Your ref:
Our ref: 21/02328/F
Please ask for: Miss Sandra Homcenko
Direct dial: 01553 616824
Direct fax: 01553 616652
E-mail: borough.planning@west-norfolk.gov.uk

Details: **PROPOSED SINGLE STOREY SIDE EXTENSIONS AND INTERNAL ALTERATIONS
at Orton Field 146 Stow Road Wiggenhall St Mary Magdalen King's Lynn
Norfolk**

PROPOSED ROOF PLAN
 SCALE: 1:100

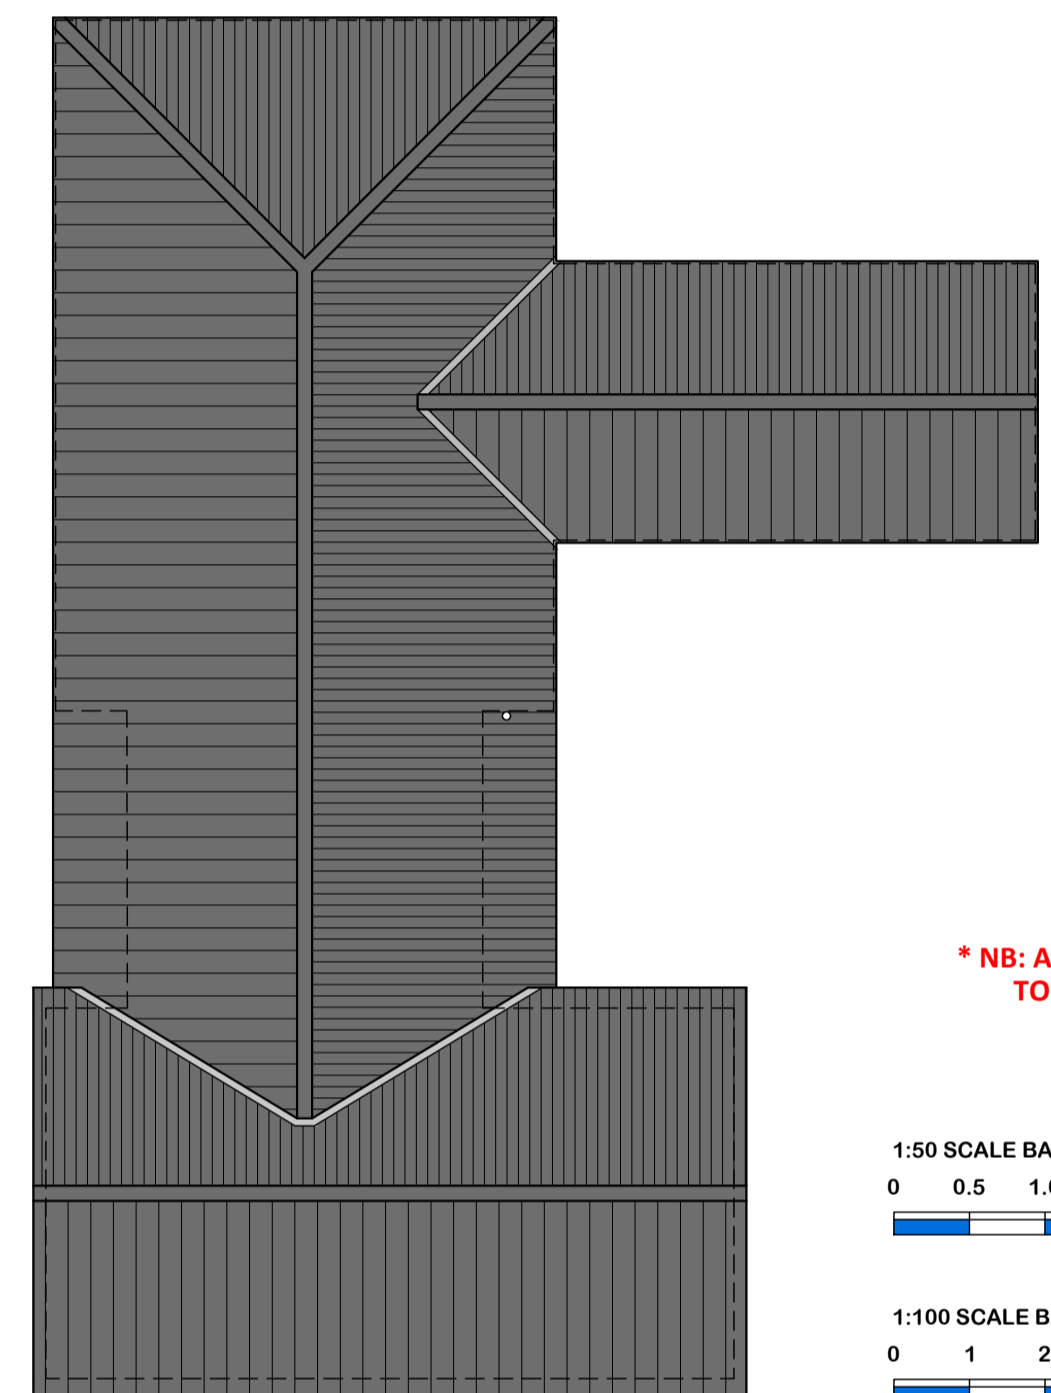
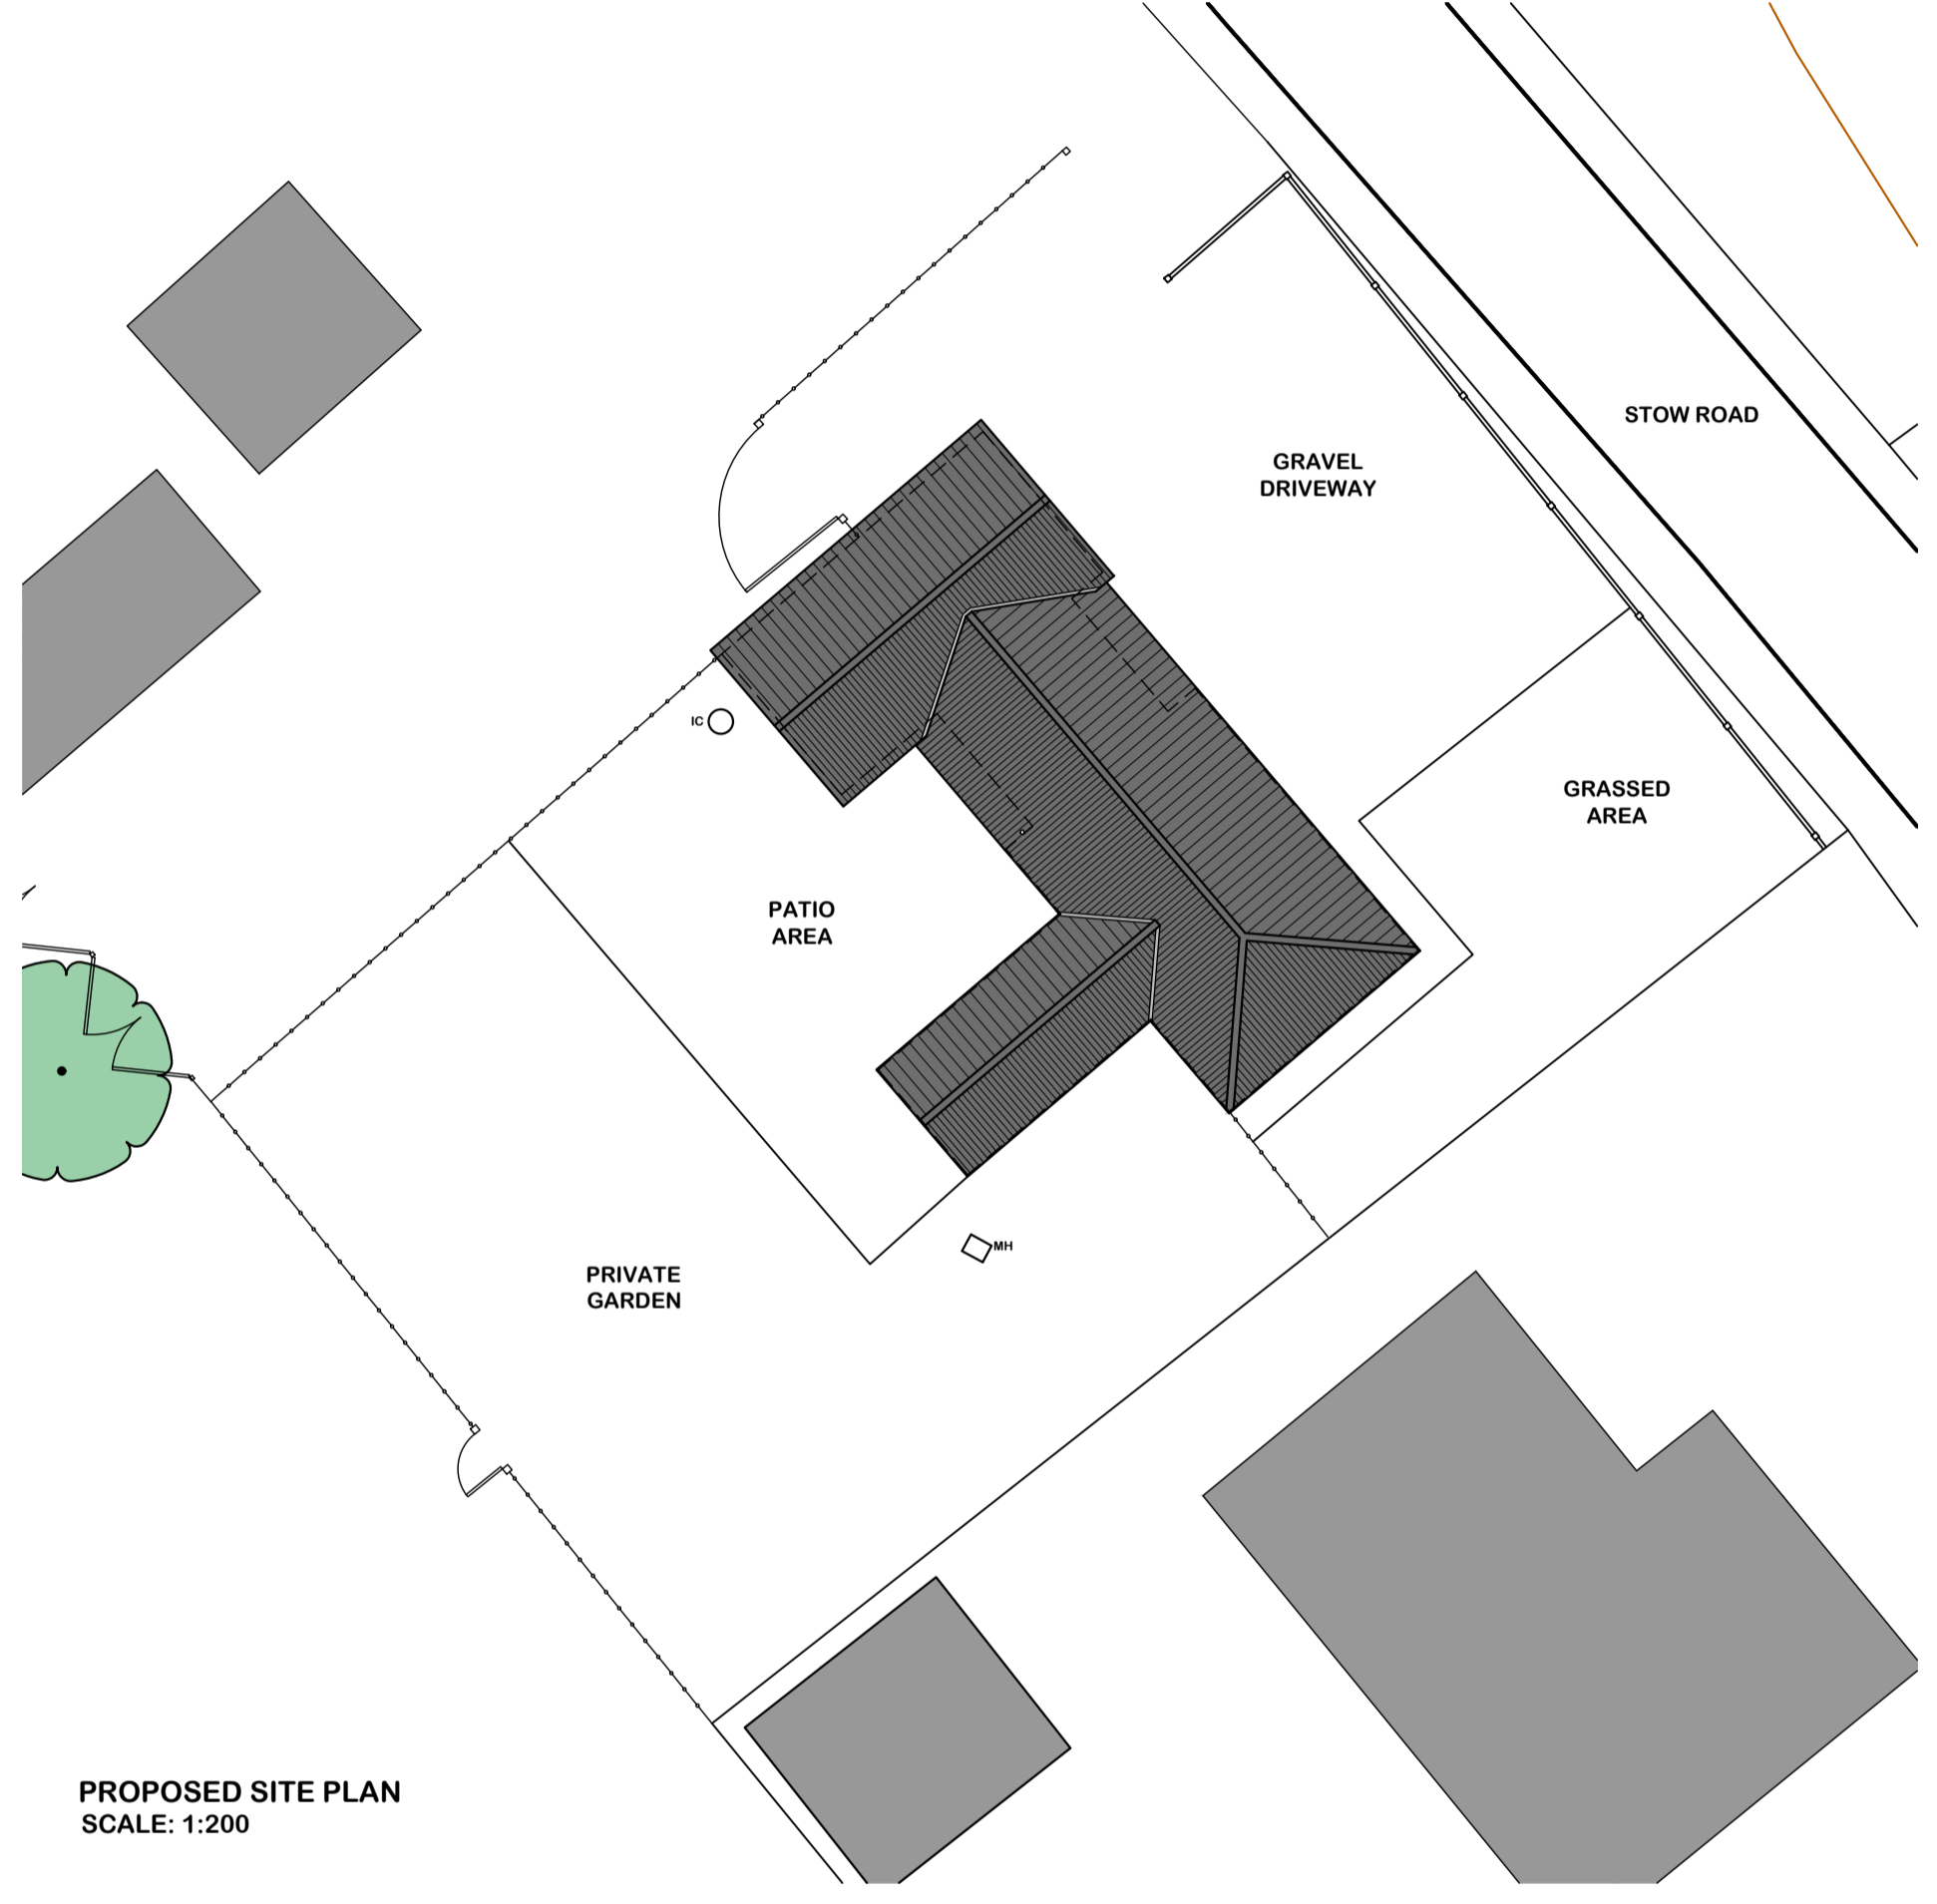
1. Please provide amended proposed floor plan showing correct position on roof lights
2. As the property lies within an area at risk to flooding, please complete the simplified Matrix and return it. The Matrix can be found at https://www.west-norfolk.gov.uk/info/20173/information_for_planning_agents/231/flood_risk_information
